**Addendum No. 1**

RE: Contract # C204255

**Alleghany County (B-5388)**

Bridge #21 Over Little River On NC-18

TEMPORARY DETOUR FOR BLASTING/CLEANUP OPERATION

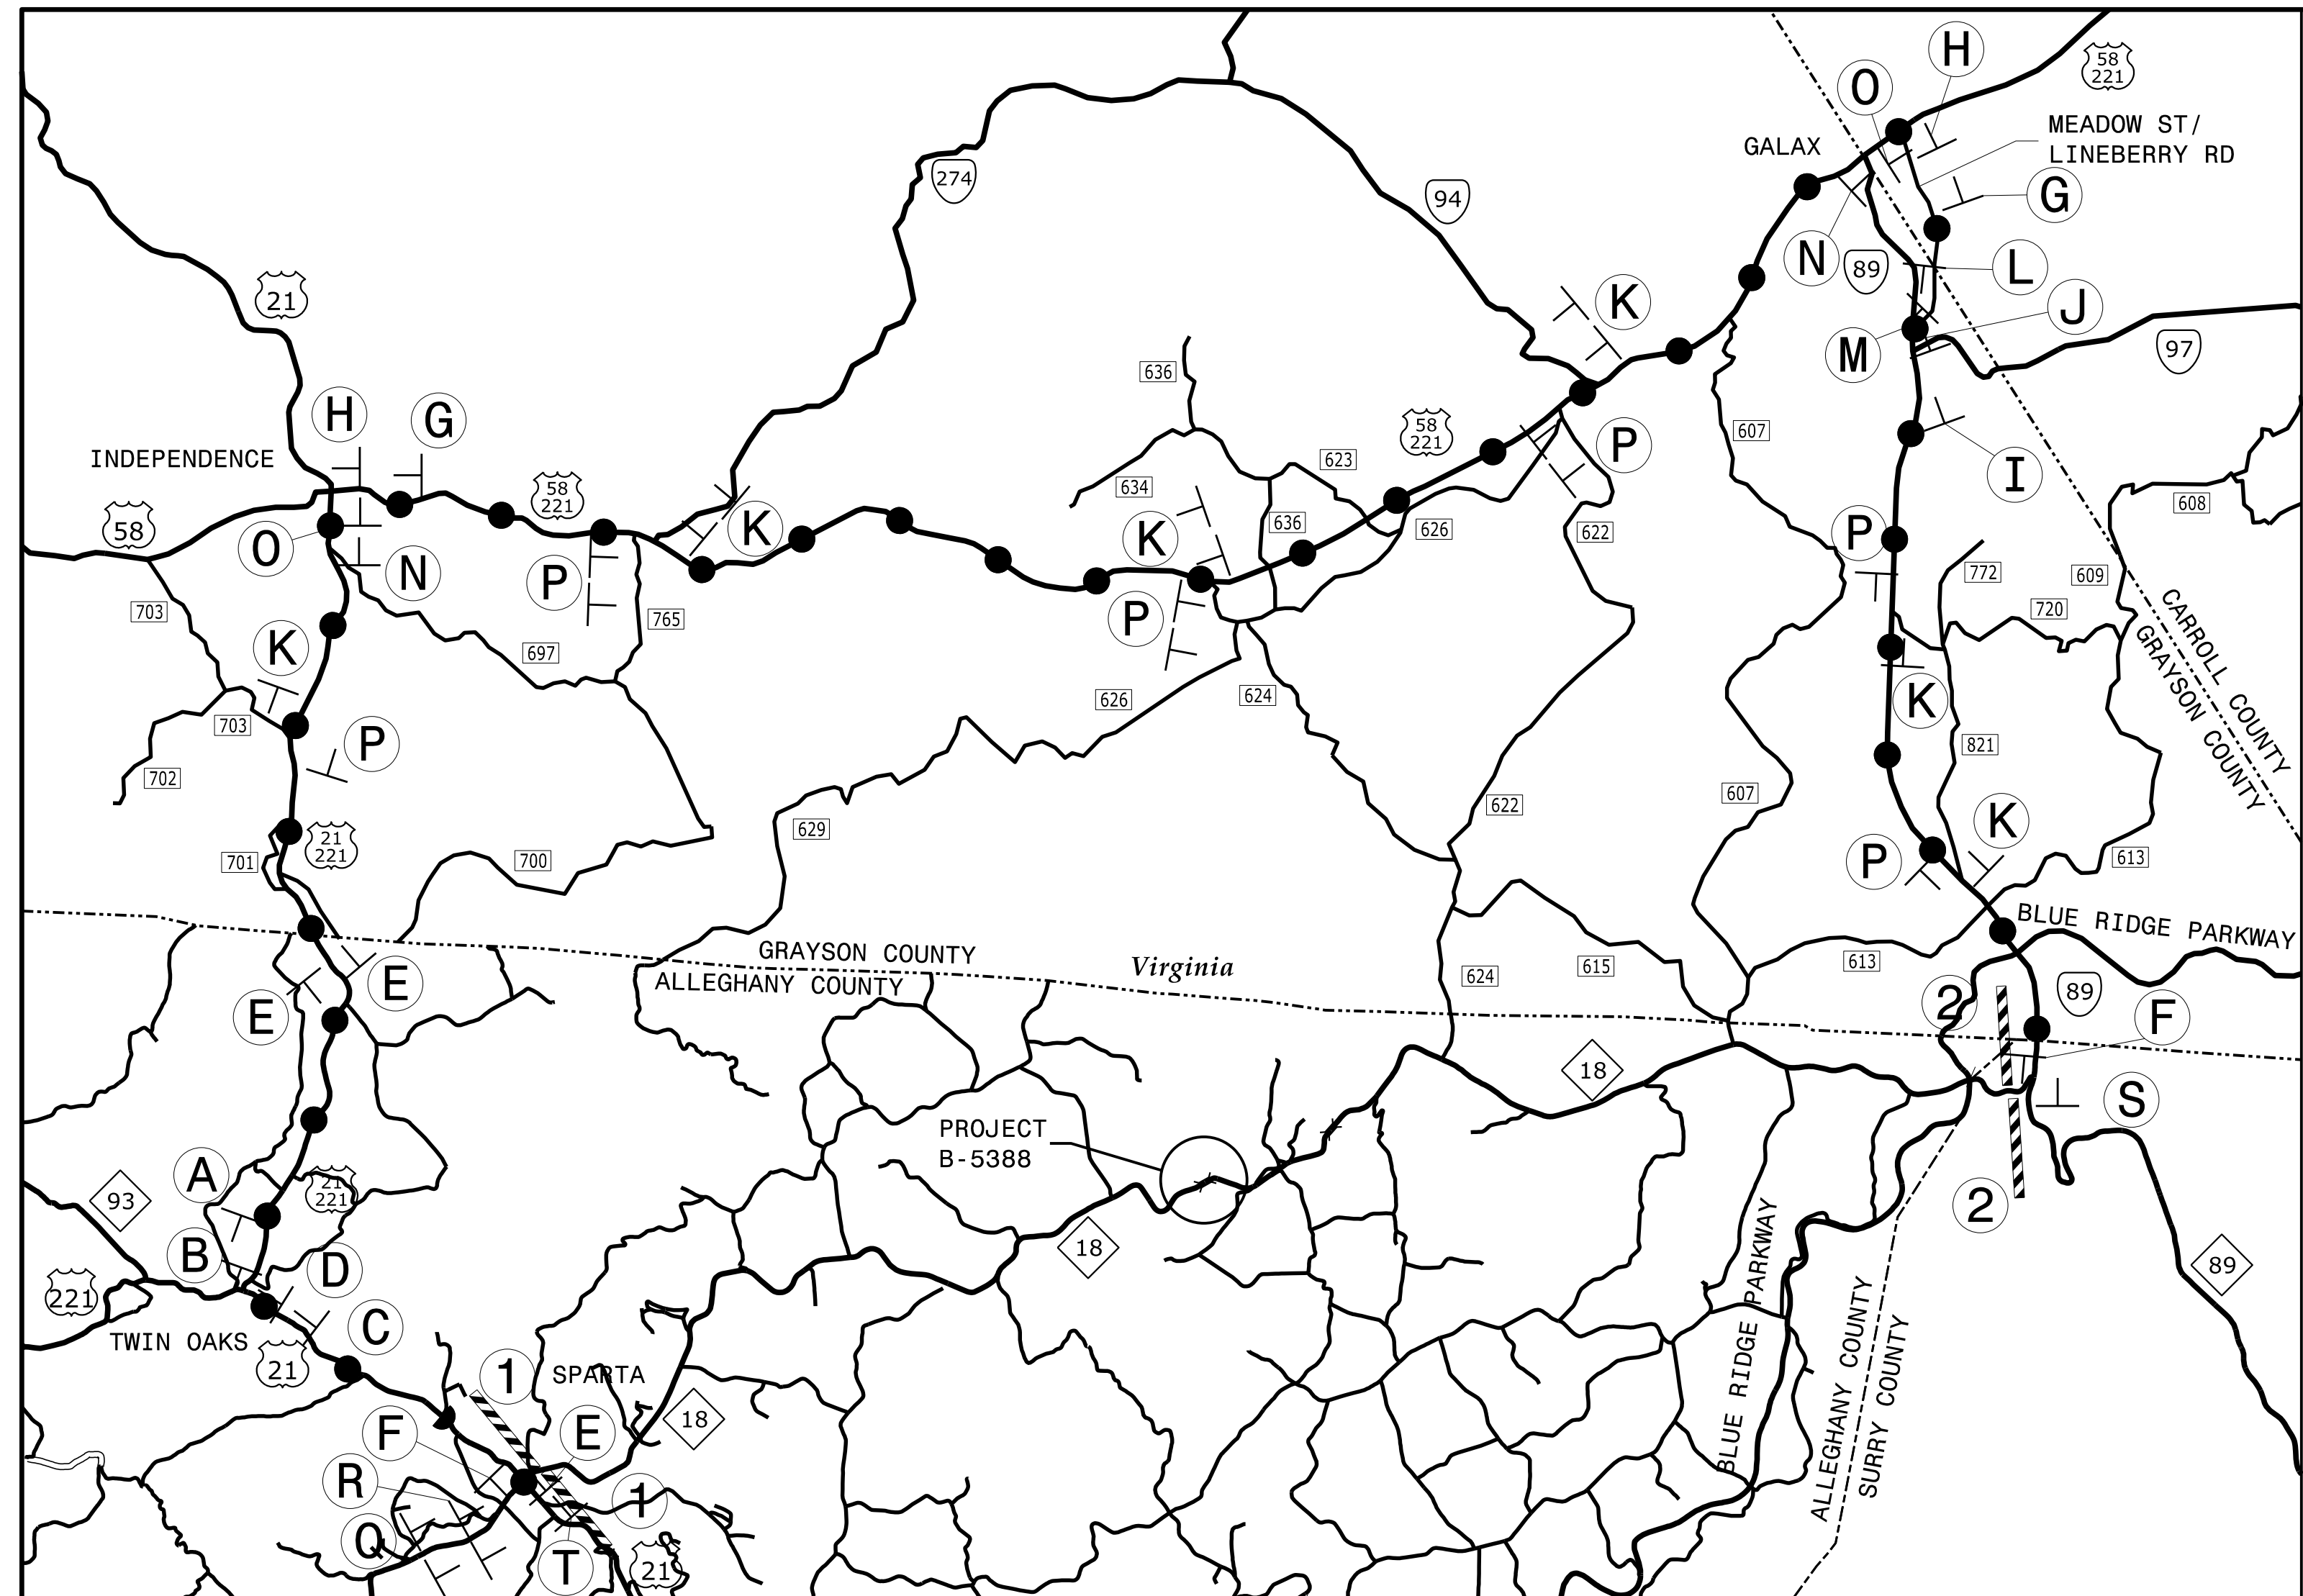
Sheet No.	Revisions
TMP-6	Revised detour route signage in VA to comply with VDOT's Work Area Protection Manual

Please void Sheet No. TMP-6 in your plans and staple the revised sheet thereto.
